**Re: Abrazo Homes at Montage Unit 5 (Lots full legal description?)
Erosion and Sediment Control Plan
Engineer's Stamp Date 1/8/25 (R16E006C_A)**

Based on the information in your submittal received on 1/9/25, the above-referenced ESC Plan can't be approved until the following comments are addressed.

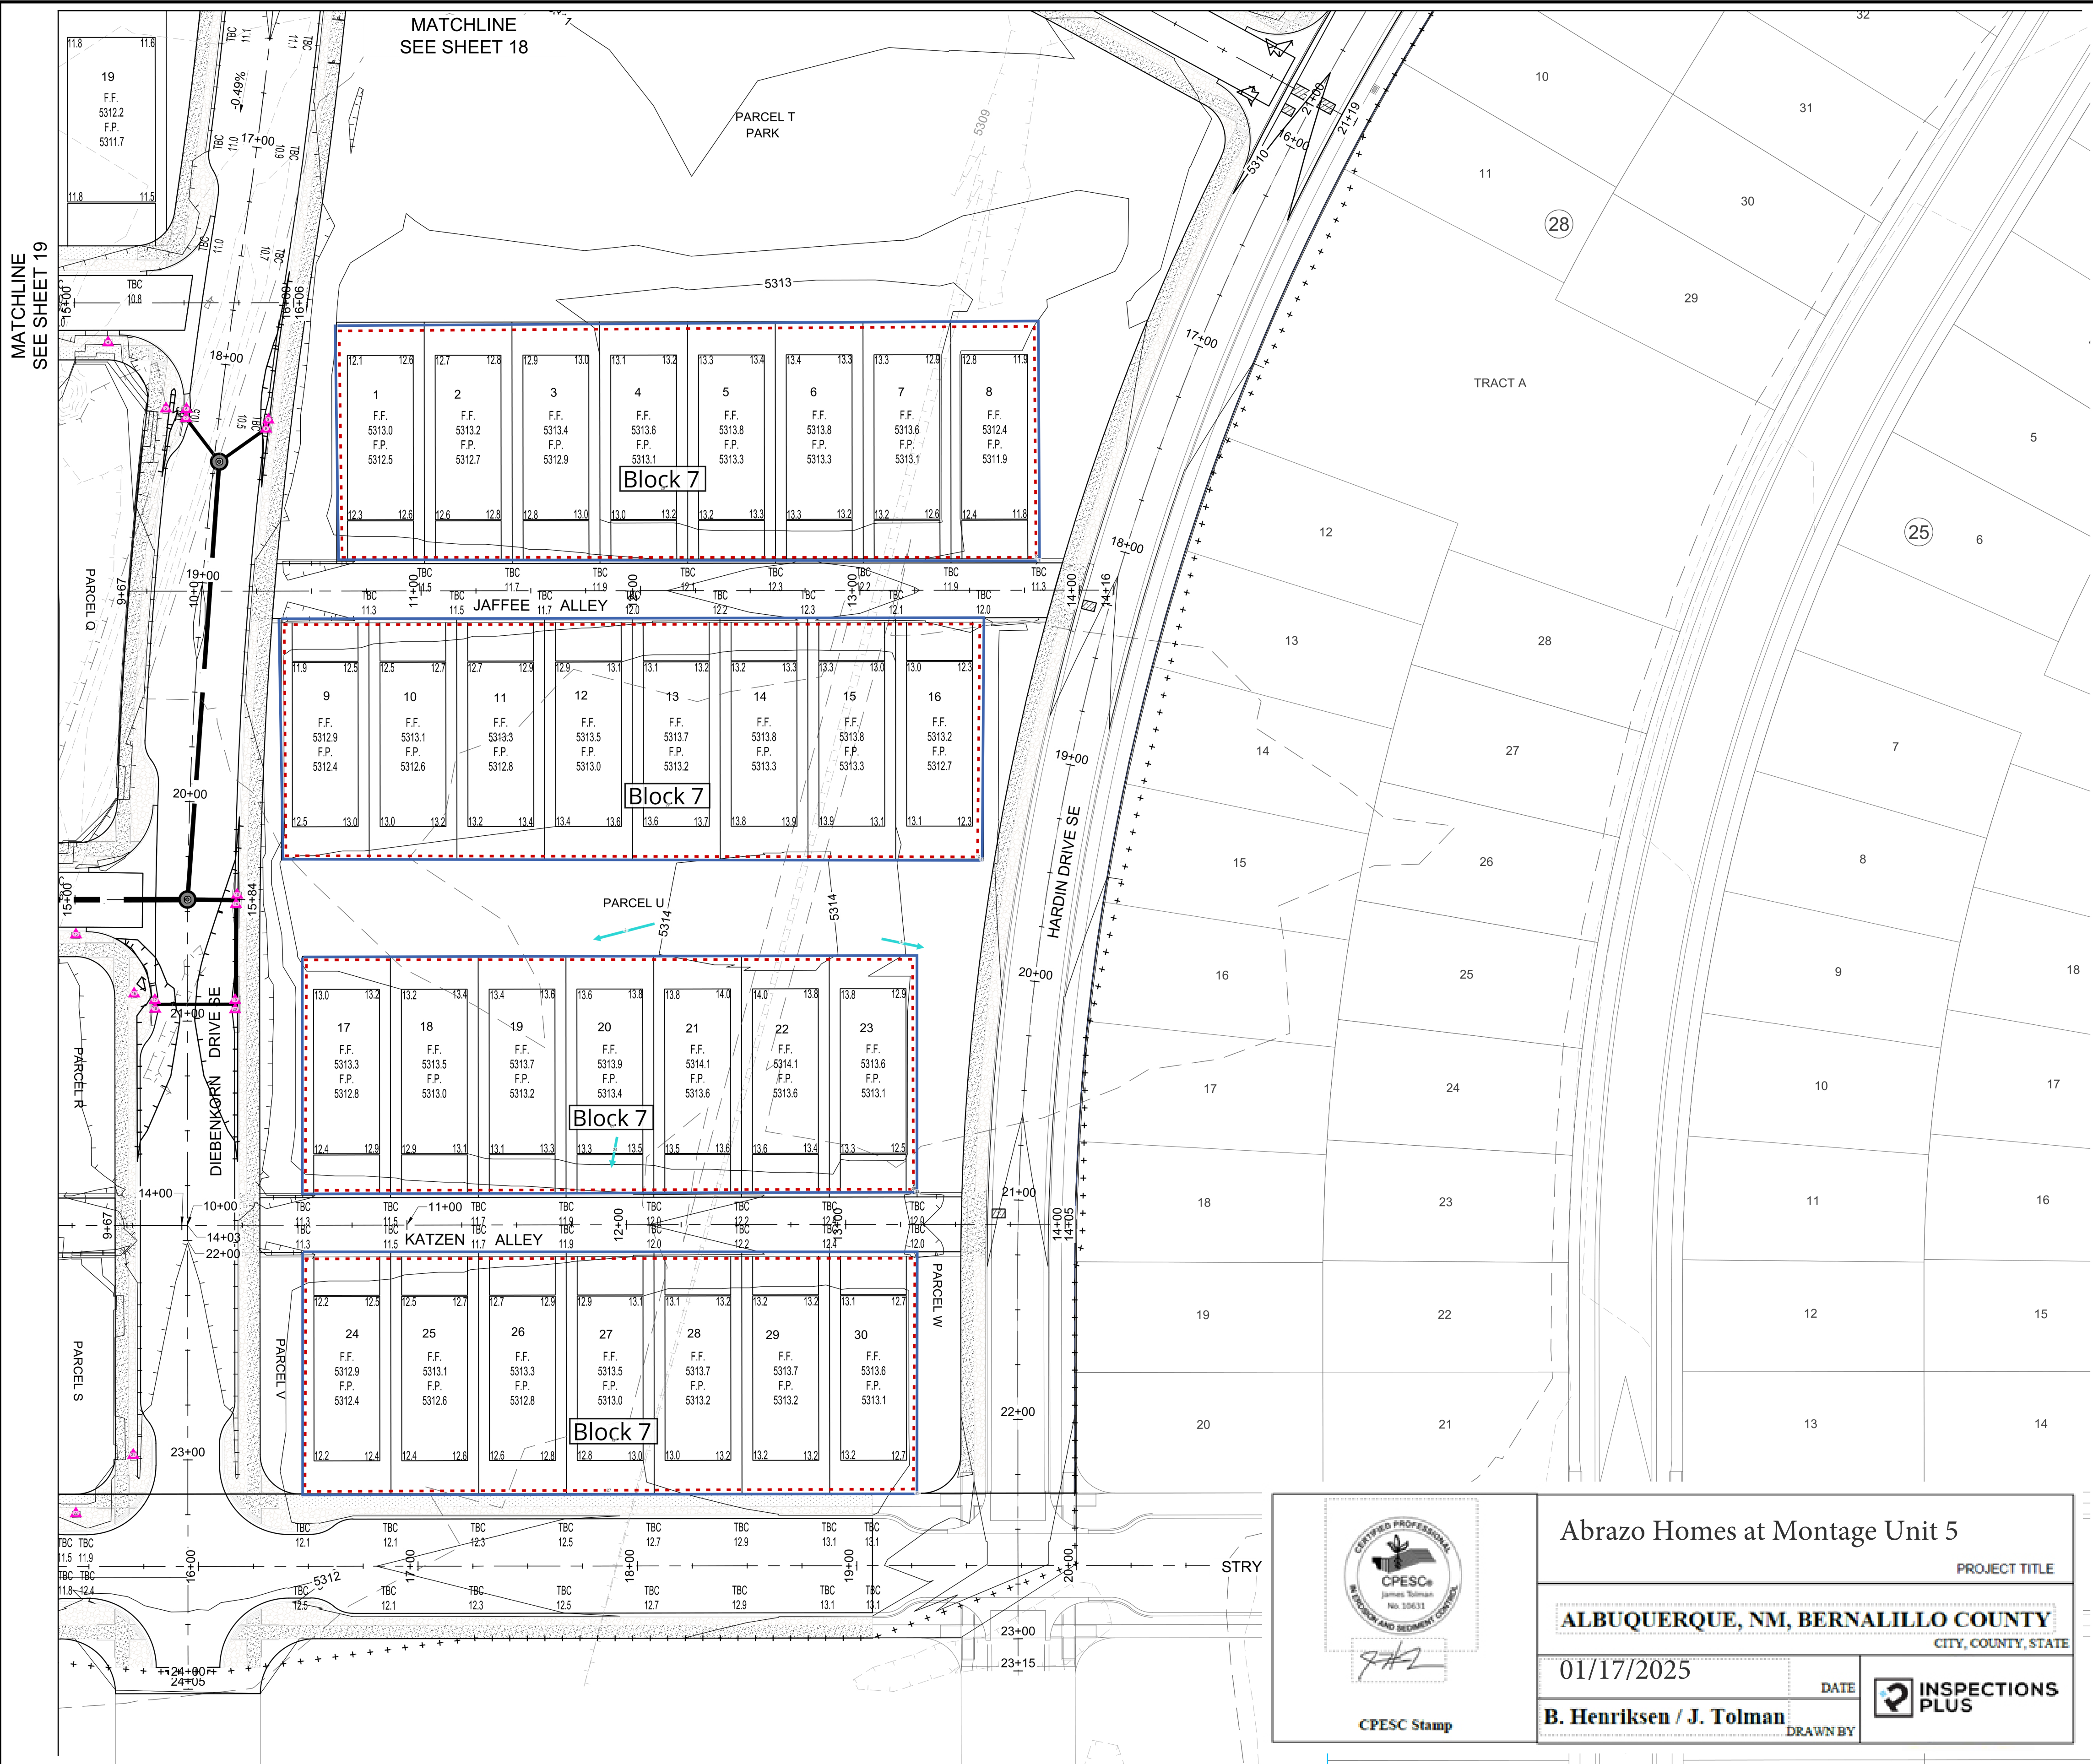
1. The Block numbers are missing from the ESC Map and the list of Lots. Add the block numbers.
2. Correct the "Operator Name," "Project Name," and Phone number in the "Operator Point of Contact Information" on the NOI. The Operator Name on the NOI must always be spelled as it is on the deed, with no missing, extra, or changed letters. Since the "Project Name" includes lot numbers with no block numbers, it is inaccurate and misleading. You may use a more general project name, such as "Abrazo at Montage Unit 5". The "Operator Point of Contact" is Mackenzie Bishop, but the phone number on the NOI and on the SWQ Information Sheet is for Steve Hernandez. A working phone number for Mackenzie Bishop is required on both the NOI and the SWQ Information Sheet.
3. Update the engineer's stamp date on all sheets when a change is made to any sheet.
